**Re: Lot 26-A, Block J, Lavaland Addition, 65th ST & Central NW,
Traffic Circulation Layout
Engineer's Stamp dated 5/31/13 (K11-D082)**

Based upon the information provided in your submittal received 5/31/13, the above referenced plan cannot be approved for Building Permit until the following comments are addressed:

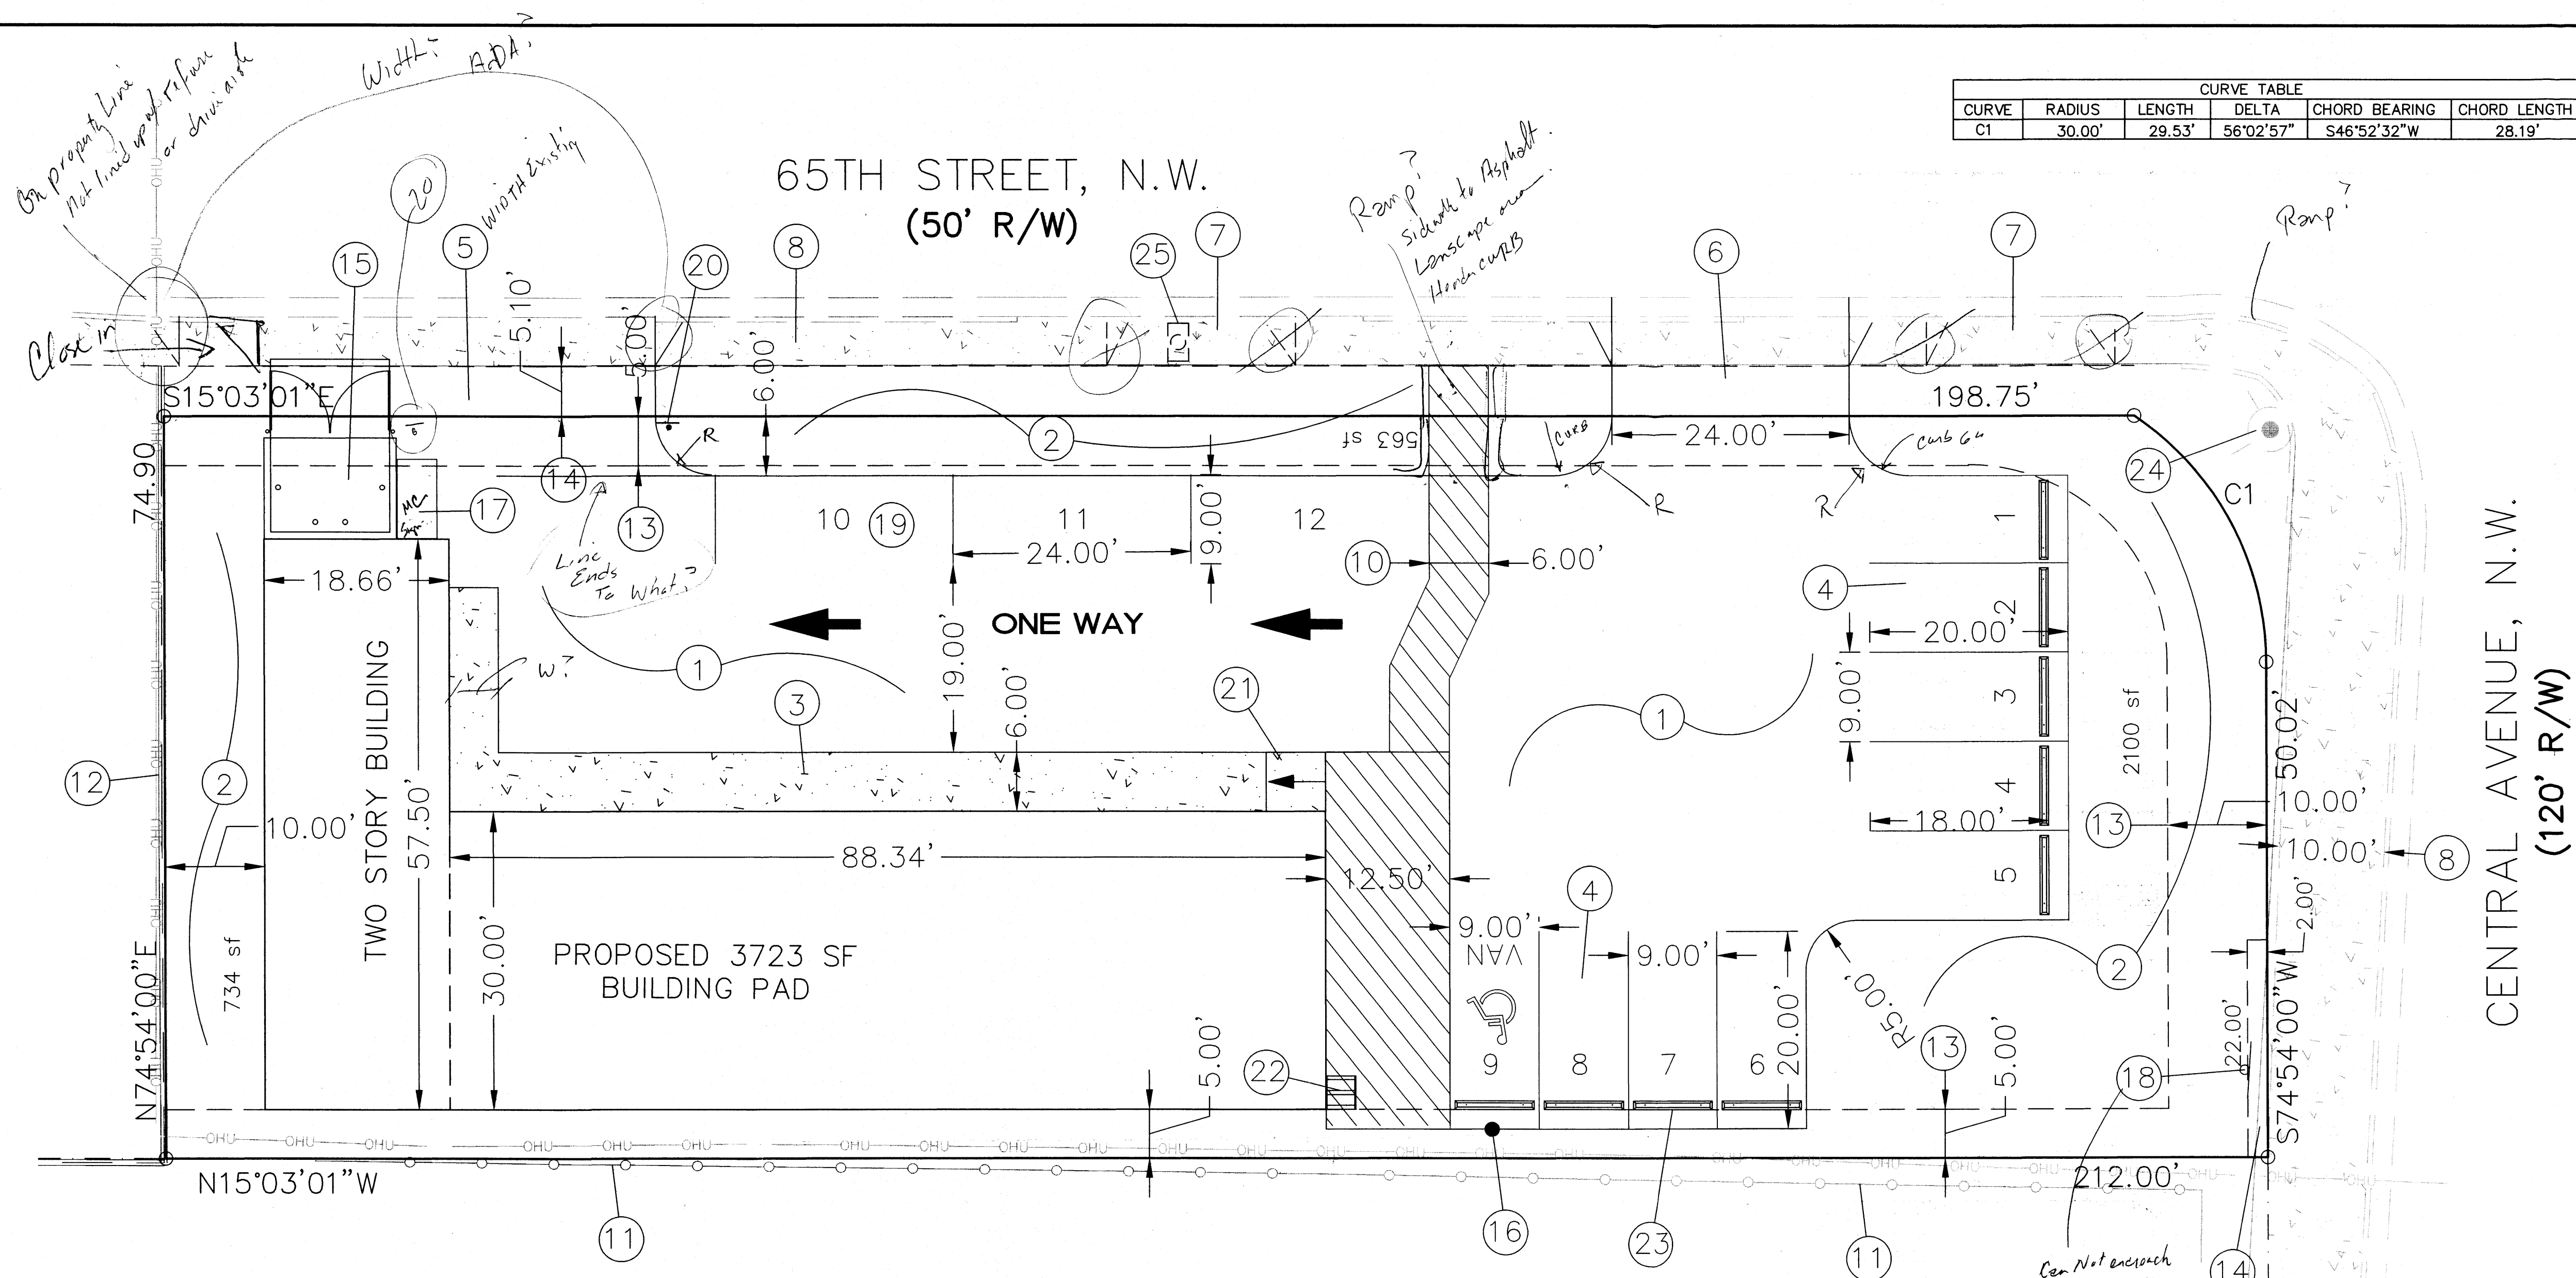
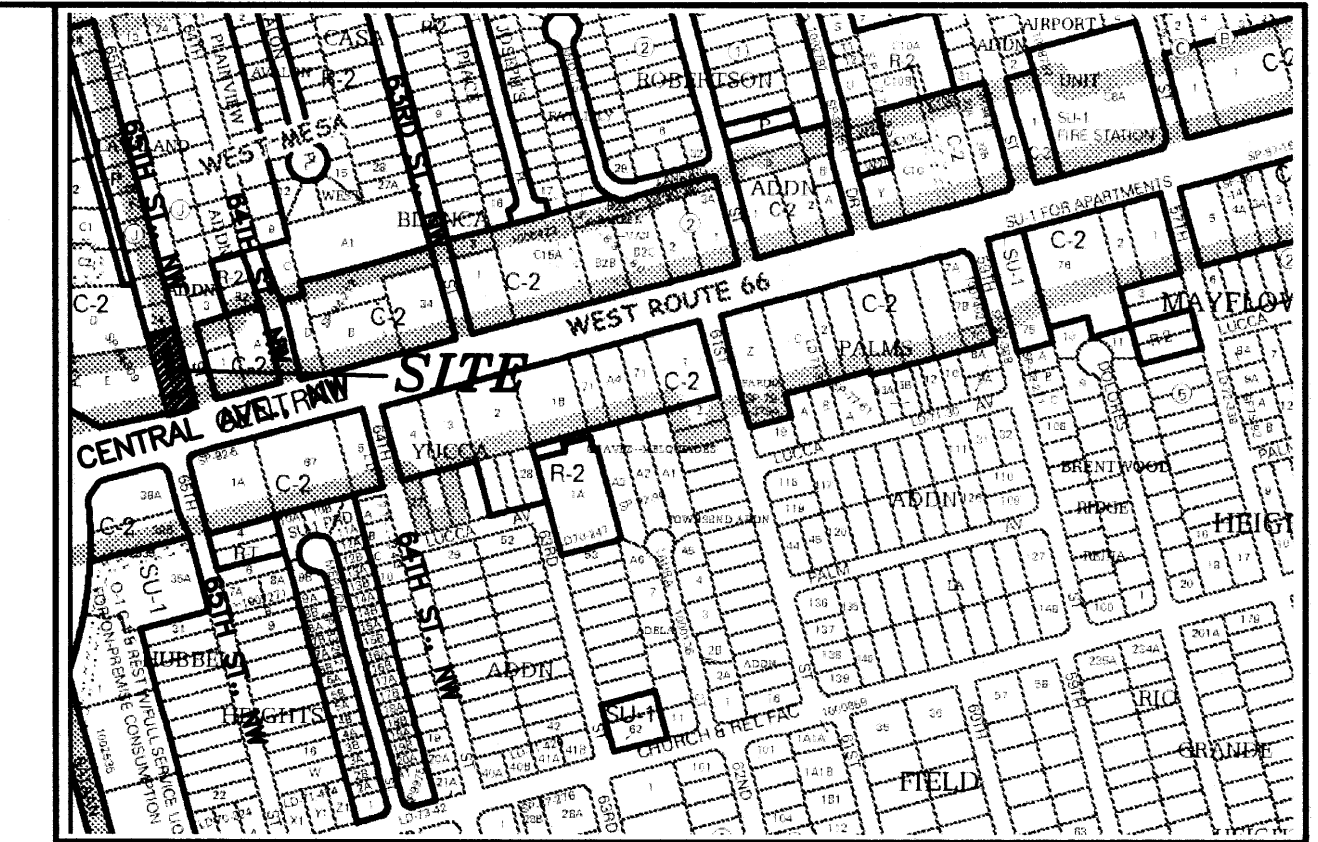
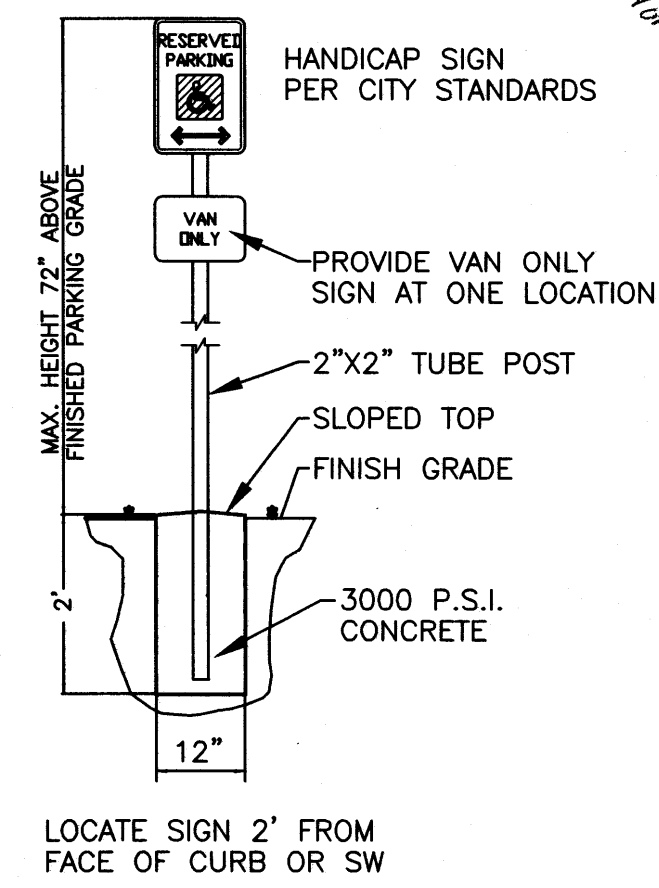
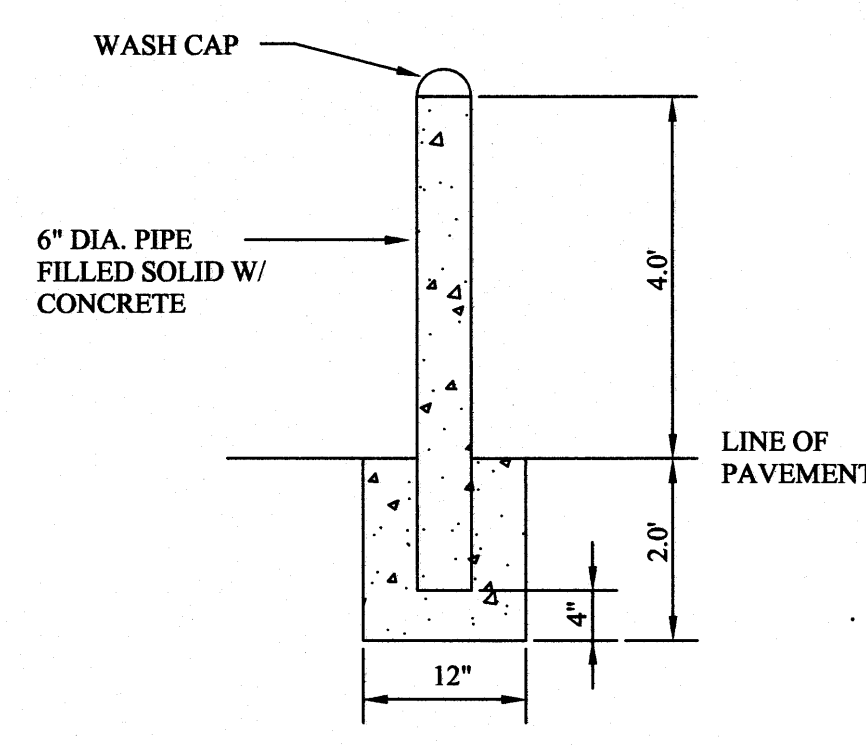
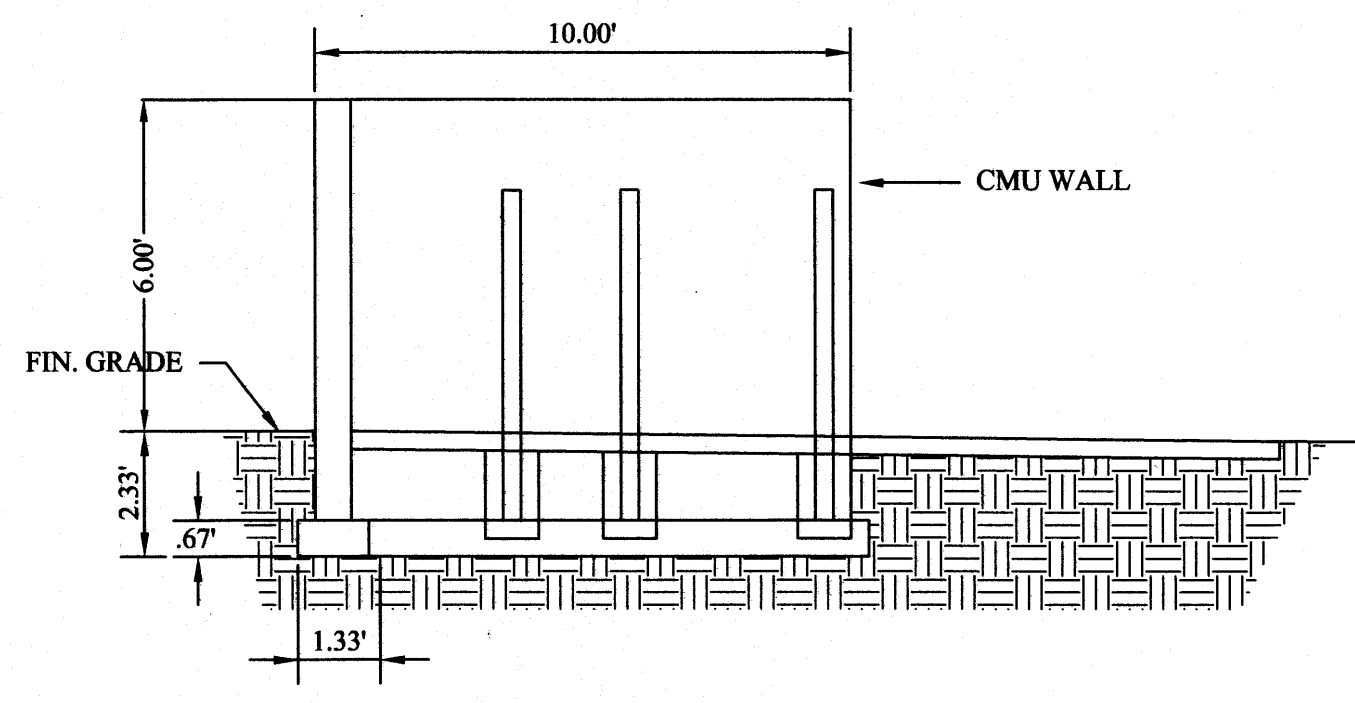
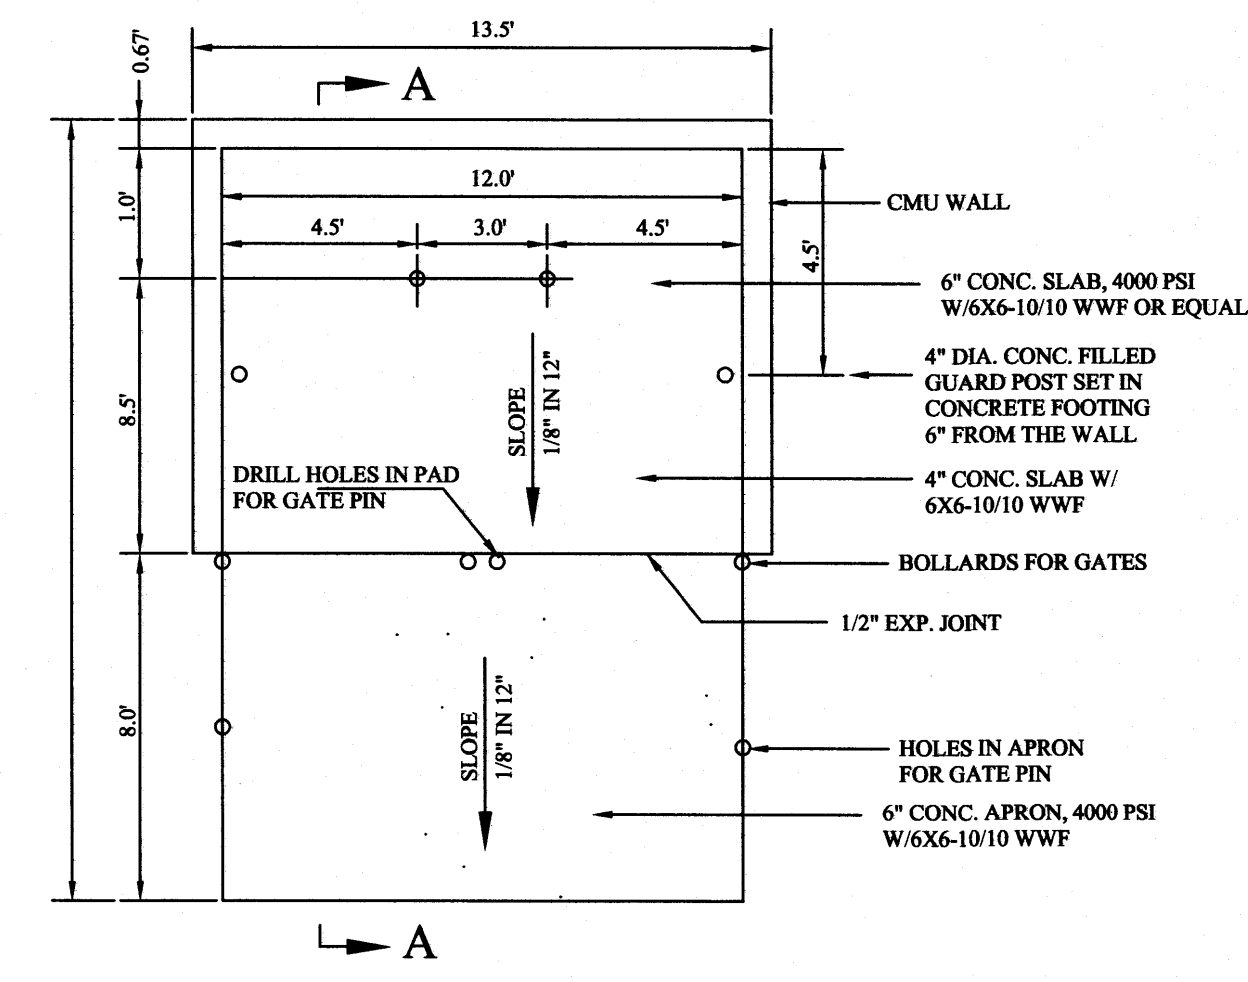
1. Please include two copies of the traffic circulation layout at the next submittal.
2. List radii for all curb returns associated with drive pads; for passenger vehicles, the minimum radius is 15 feet.

3. Please label and dimension proposed curbing. Curbing should be used to separate landscaping from parking areas and pedestrian ways.
4. Keyed Note #9 is not used.

5. Please provide posted signage for motorcycle stall.
6. Please refer to all applicable city standards.
7. Please ensure all ramps are ADA compliant.
8. Please clarify keyed note #10 pedestrian access way: Pavement striping? Asphalt surface? Elevation difference between public sidewalk and parking area? ADA ramps? Header curb cuts? Please provide details.

9. Show a detail of the wheelchair ramps located at the proposed driveway, or refer to the appropriate city standard.
10. List the width of the existing drive pad to remain. Please note the drive pad keyed note #5 refers to an "entrance" but the site layout indicates it functions as an exit only.

11. Please add an additional "Do Not Enter" sign at the one way exit, providing signage on both ends of the driveway. The signs must be placed within the property.

12. The existing drive pad on 65th must be reduced to accommodate the drive aisle and the refuse width only. Please reconfigure curb cut.
13. Has Lee Whistle, COA refuse, approved the location of the dumpster enclosure?
14. The existing sign, keyed note #18, can not overhang into the COA ROW airspace without a Revocable Encroachment Permit.
15. The proposed landscape area may interfere with the sight distance of the intersection. Please add the following note: "Landscaping and signing will not interfere with clear sight requirements. Therefore, signs, walls, trees, and shrubbery between 3 and 8 feet tall (as measured from the gutter pan) will not be acceptable in this area." Please see sight distance exhibit at street intersections for clarification (the *Development Process Manual*, Chapter 23, Part B, Section 5.a).
